Nina Ruiz
 El Paso County Planning & Community Development
 2880 International Circle
 Colorado Springs, CO 80910

July 19, 2017

**RE: Woodmen Hills Metropolitan District
 Regional Water Reclamation Facility
 Drainage Letter**

**WOODMEN HILLS METROPOLITAN DISTRICT
 REGIONAL WATER RECLAMATION FACILITY
 DRAINAGE MAP**

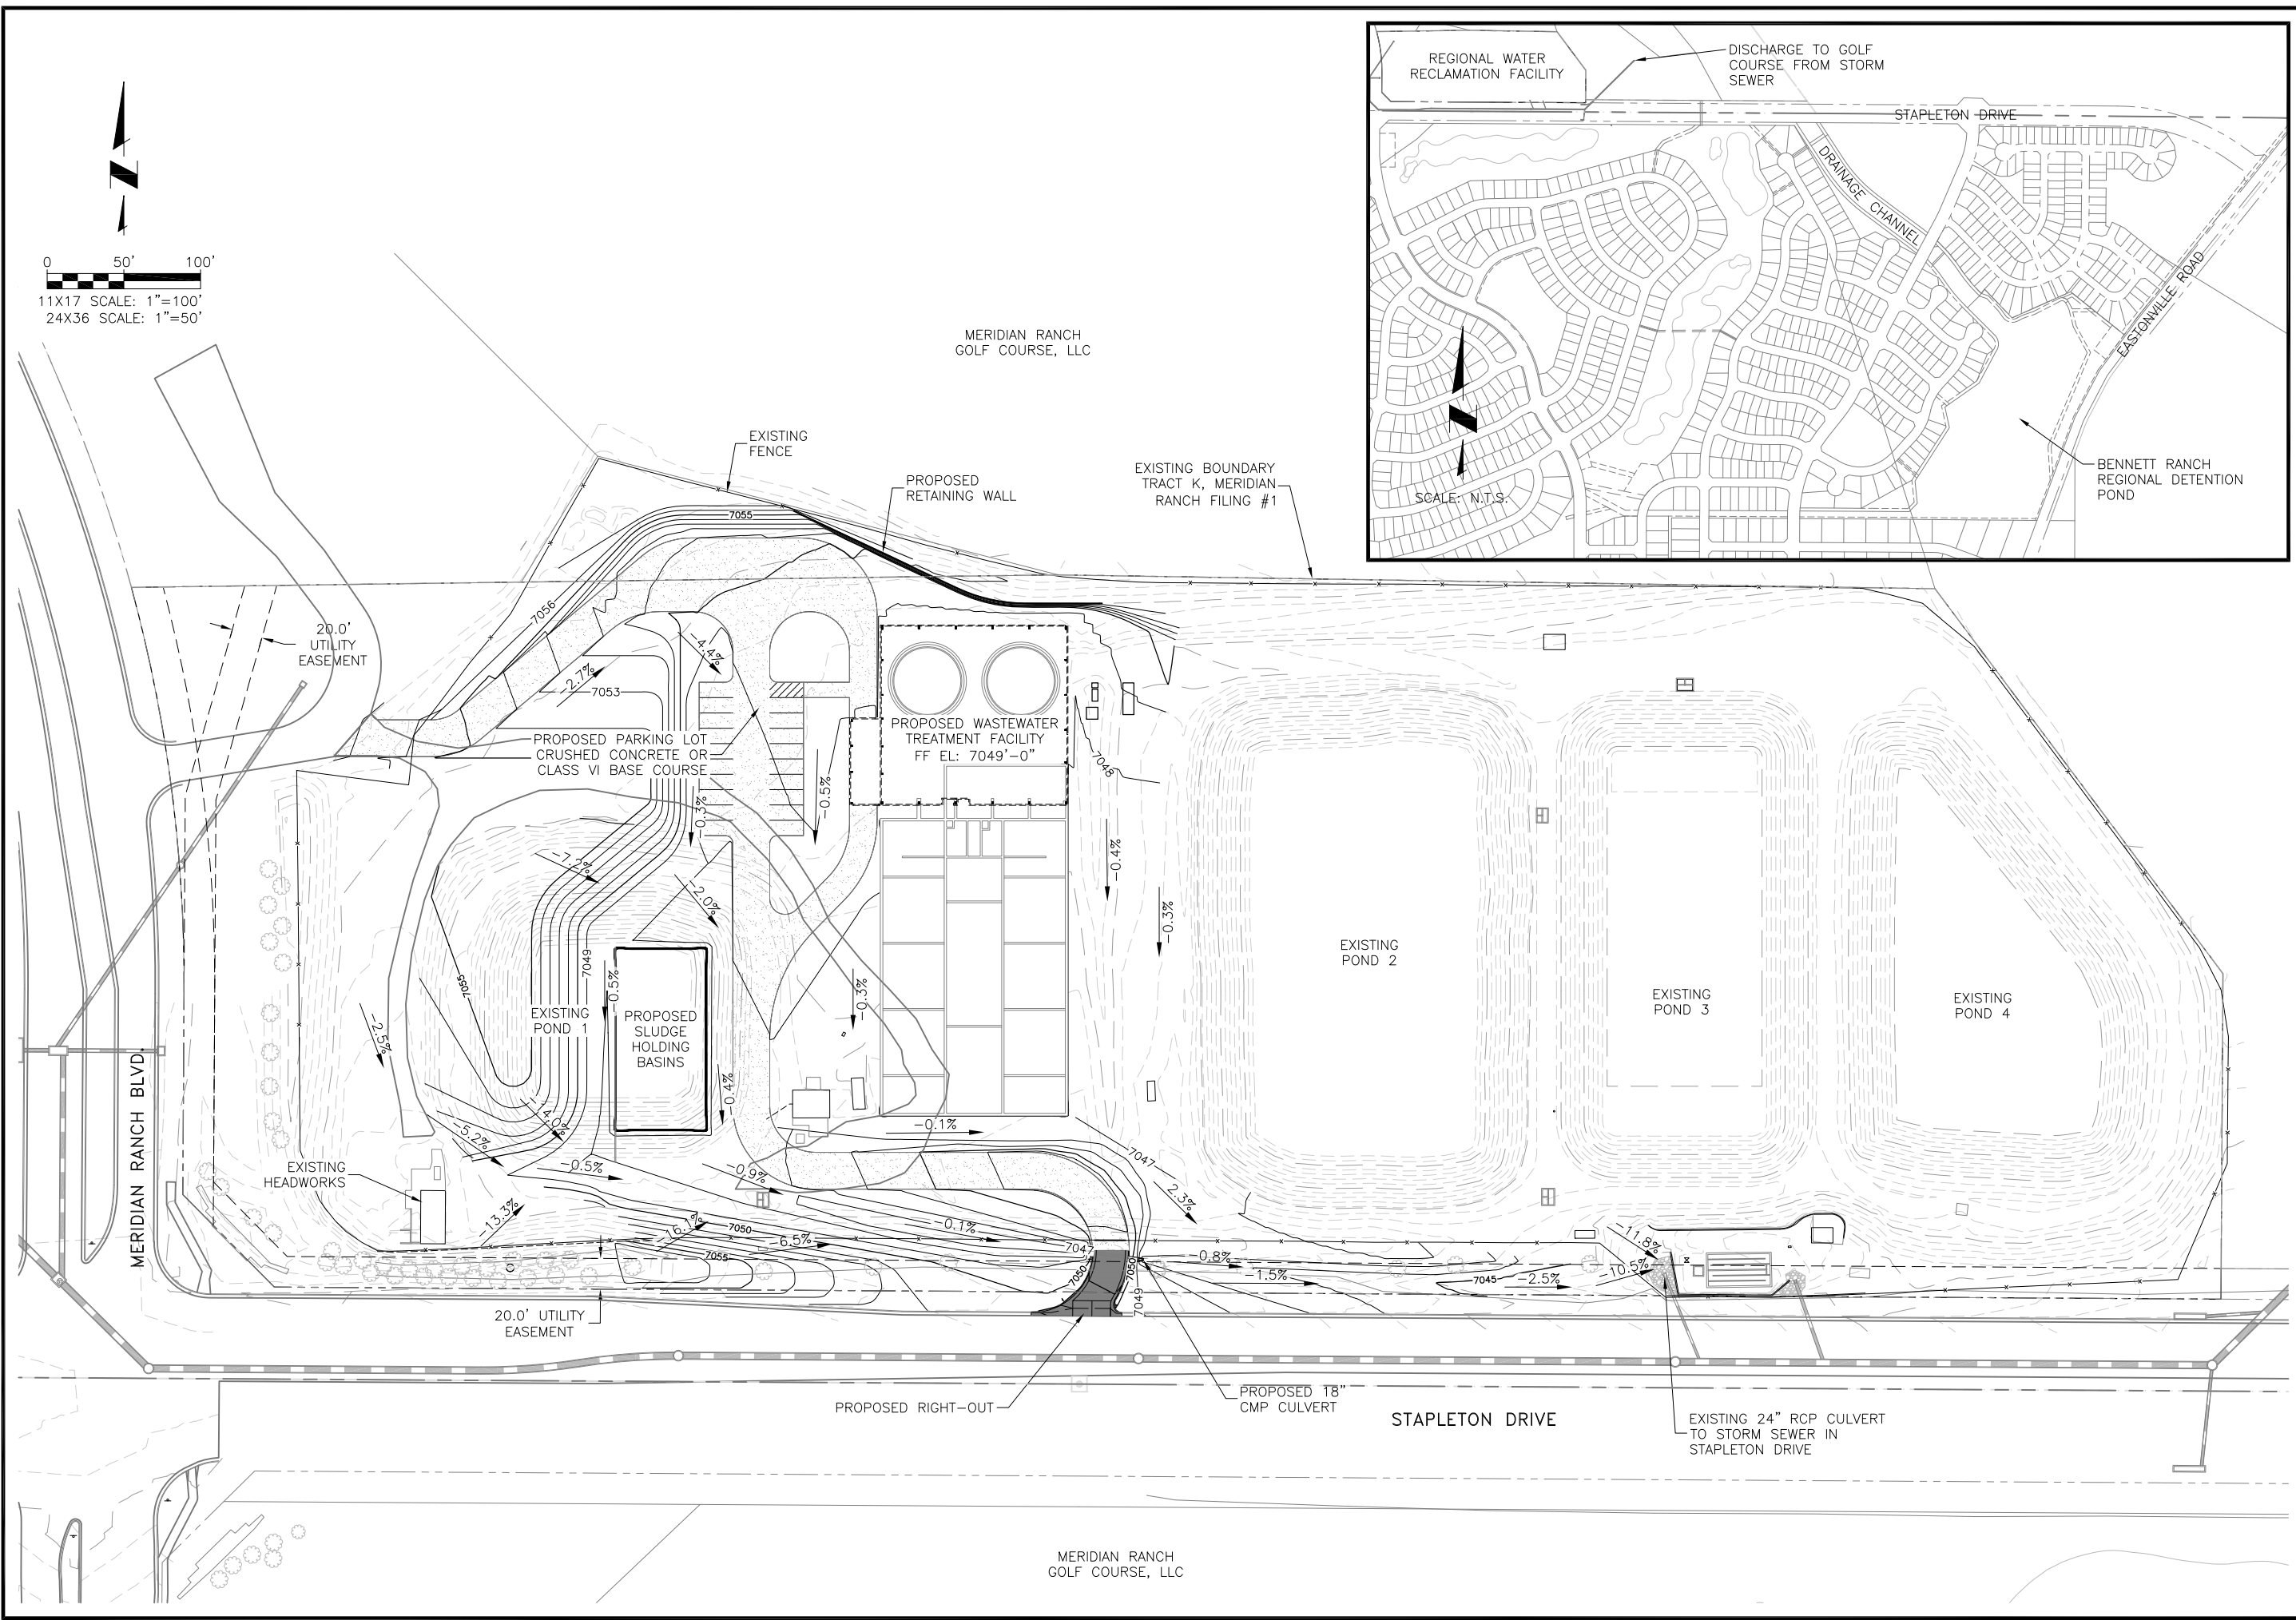
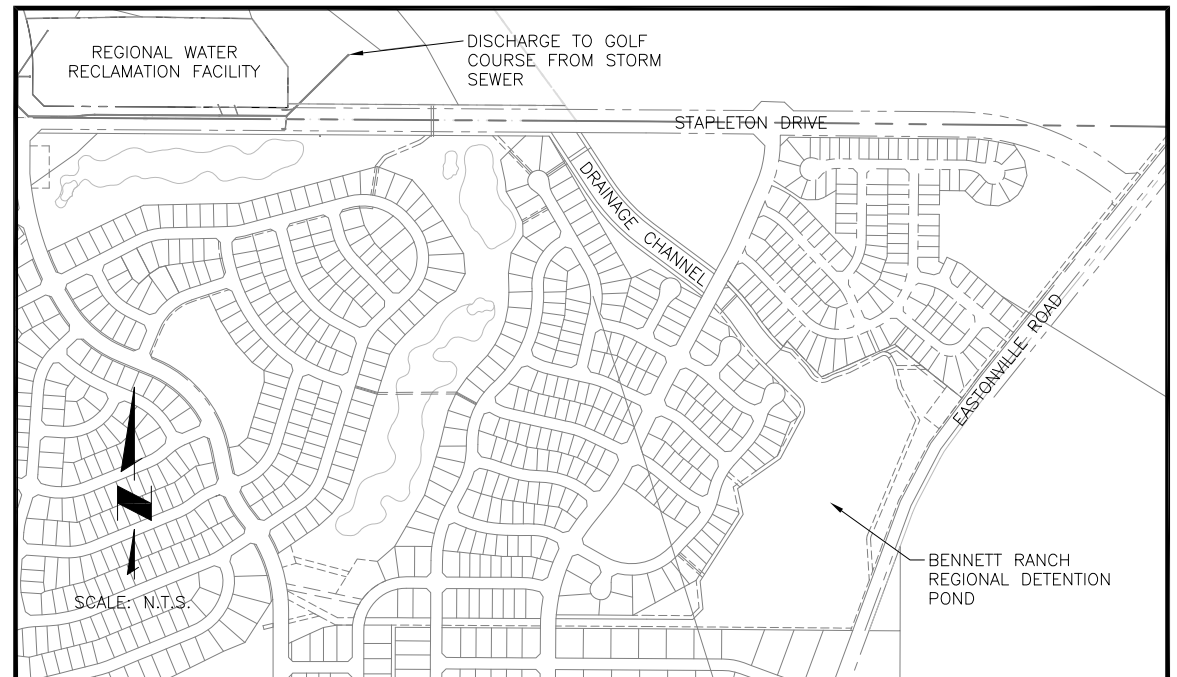
Per the DCM add the following:
 1. Cover Sheet
 2. Standard signature blocks (attached).
 3. Drainage Map.
